**Consultation Response from KC,
Lead Local Flood Authority**
2020/90441 Pennine Service Station, Bradley Road, Bradley, Huddersfield, HD2 1QD
Discharge conditons 3, 6, 7, 18 on previous permission 2019/92233 for erection of petrol filling station, including new shop building, canopy, jet-wash and below ground storage tanks
**Date Responded: 1
October 2020**
**Responding Officer:
Aleksandra Tomczyk**
Responding Ref: 04

Summary

Kirklees Flood Management and Drainage, as the Lead Local Flood Authority (LLFA), have NO OBJECTION to discharge of conditions 3, 7 and 18 for this planning application, providing the following considerations and approved documents are appended and recorded with any approval:

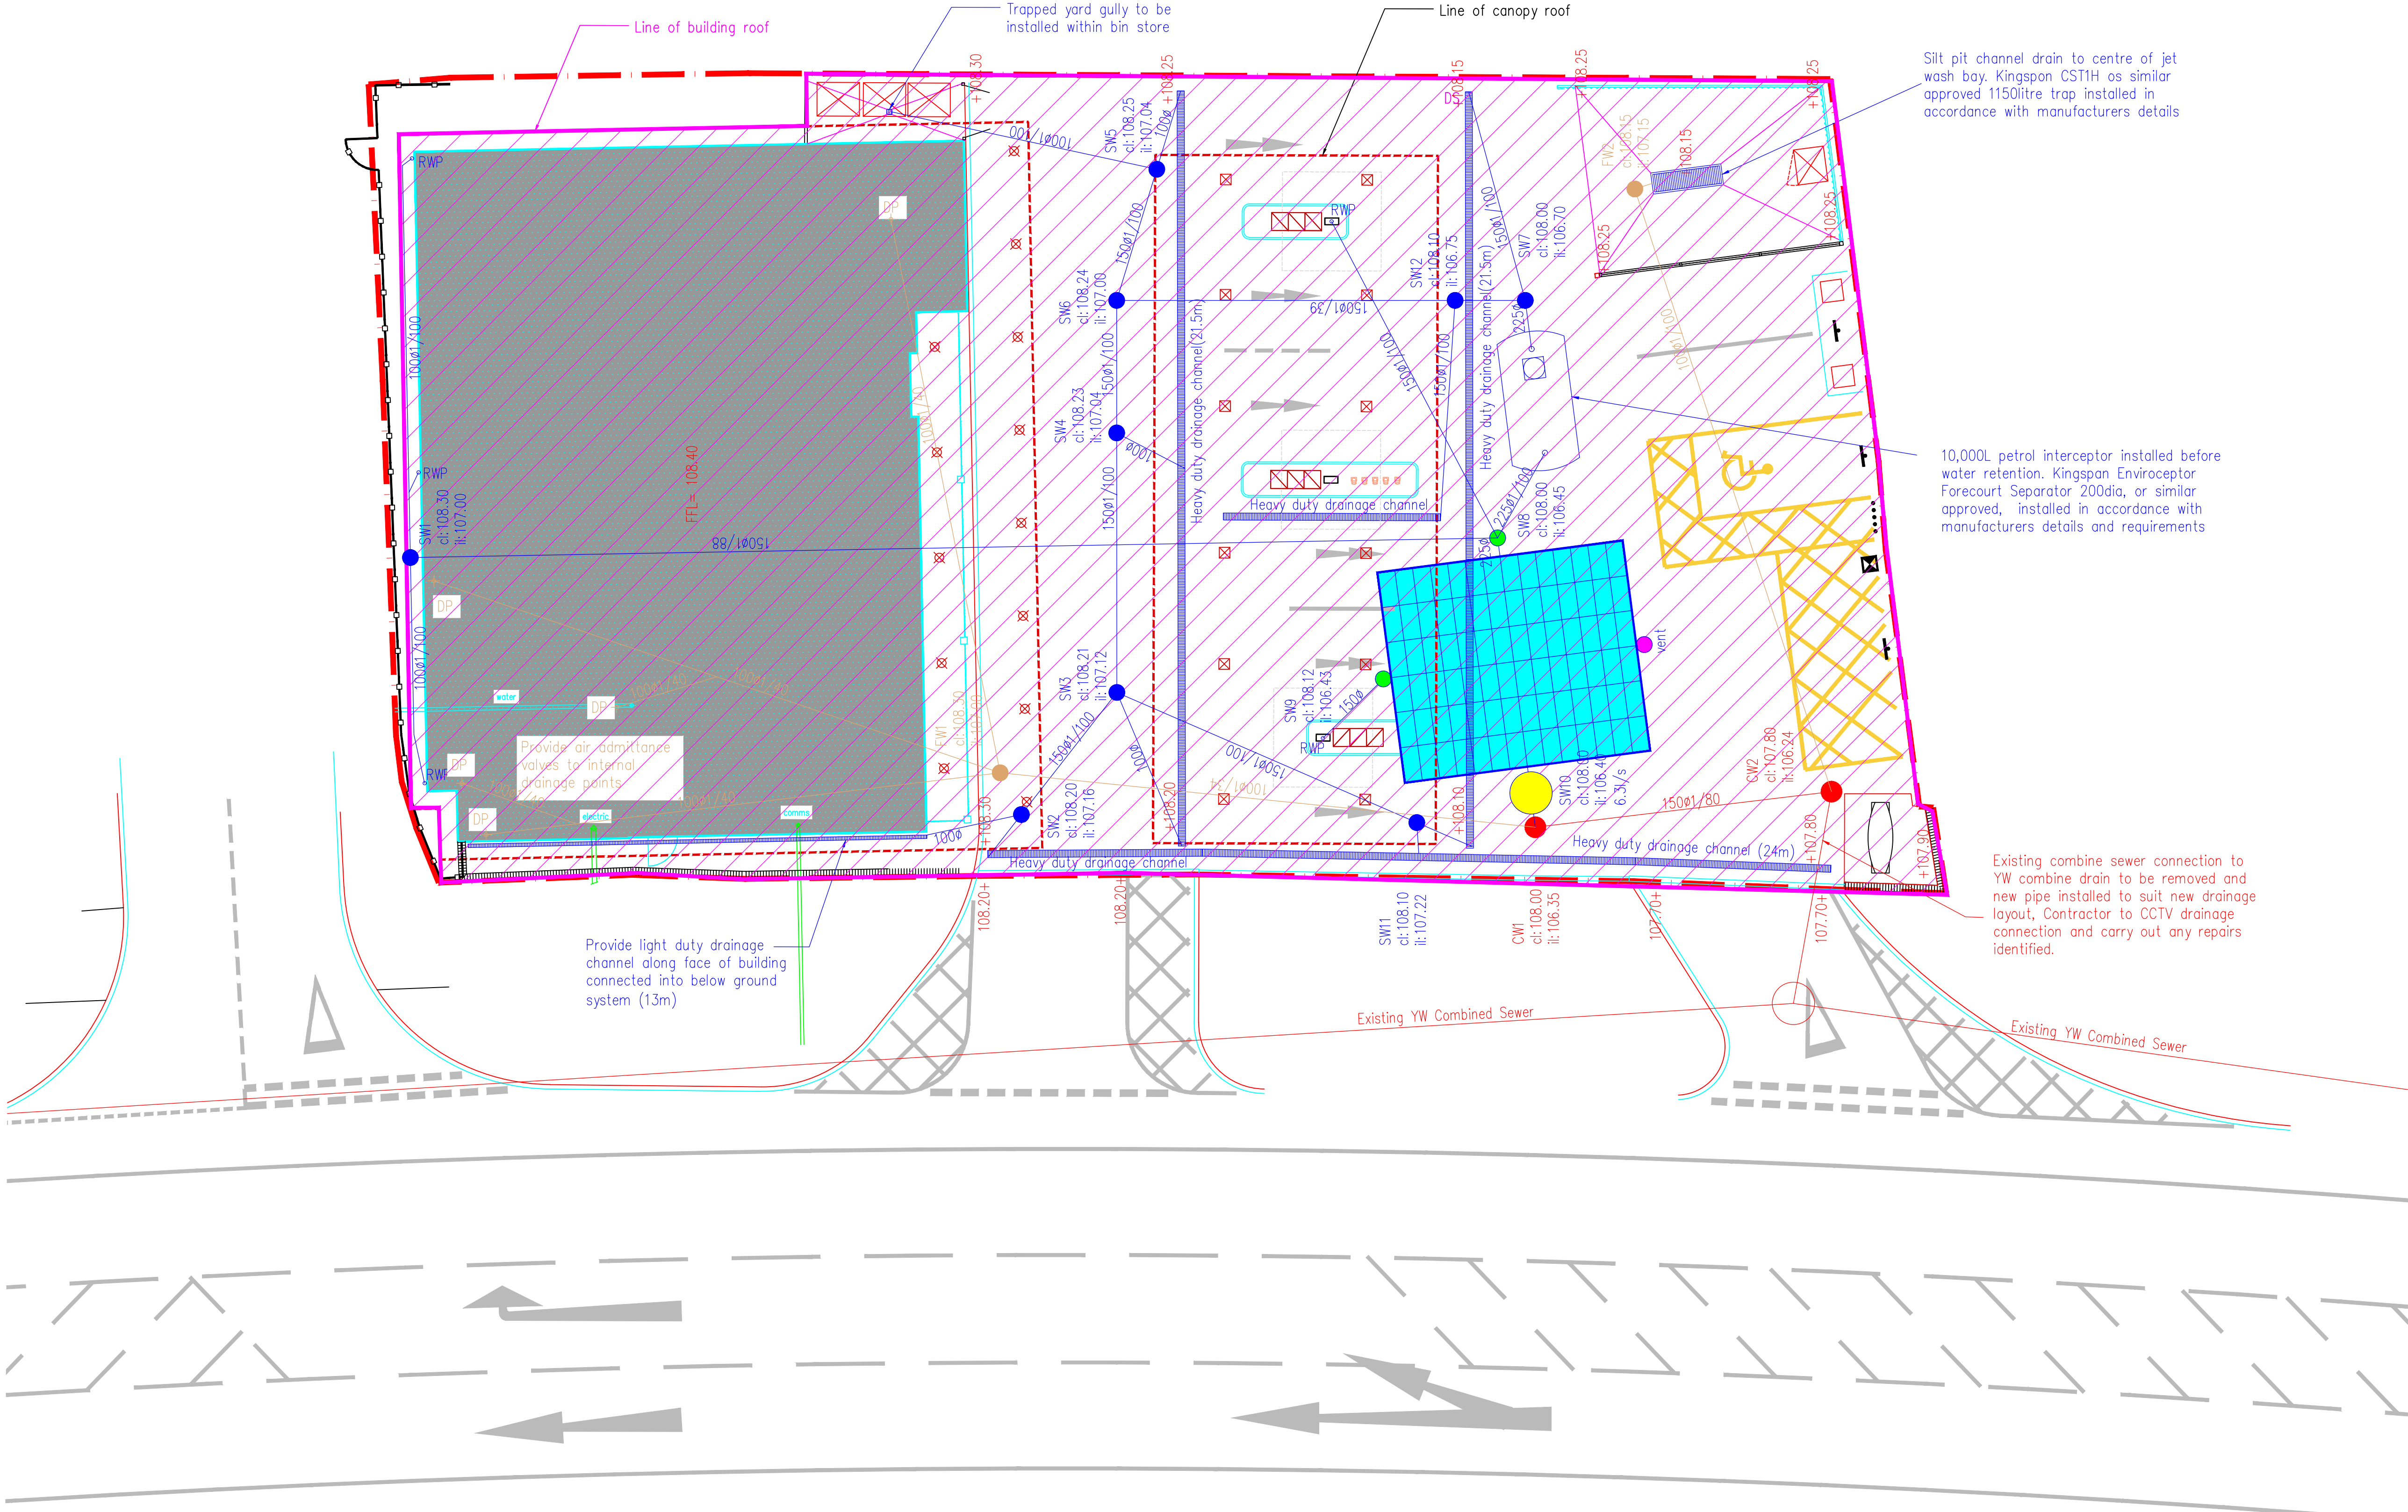
1. Annotations for the attenuation tank on plans show conflicting information. Kirklees LLFA have **no objection to an attenuation tank sized 42m² x 0.8m deep**. Any other annotations are not approved;
2. The cover depth (ground surface to top of pipe/tank) for the attenuation is proposed to be between 0.75m and 0.8m. It is the applicant's (and their engineers') responsibility to ensure the design is safe and suitable for the site use and operation. The LLFA have not instructed any design, but required the applicant to confirm appropriate cover above the attenuation tank to be resistant to vehicle trafficking. The liability for the design lies with the applicant's design engineer and any damage or failure of the system is their responsibility.

The following plans were reviewed by the LLFA and should be added to any approvals, including the points made above, highlighting inconsistencies:

- *Drainage Layout*, prepared by EWE Associates, number EWE/2497/01, revision C, dated 27/08/20; and
- *Drainage Details*, prepared by EWE Associates, number EWE/2497/02, revision C, dated 27/08/20.
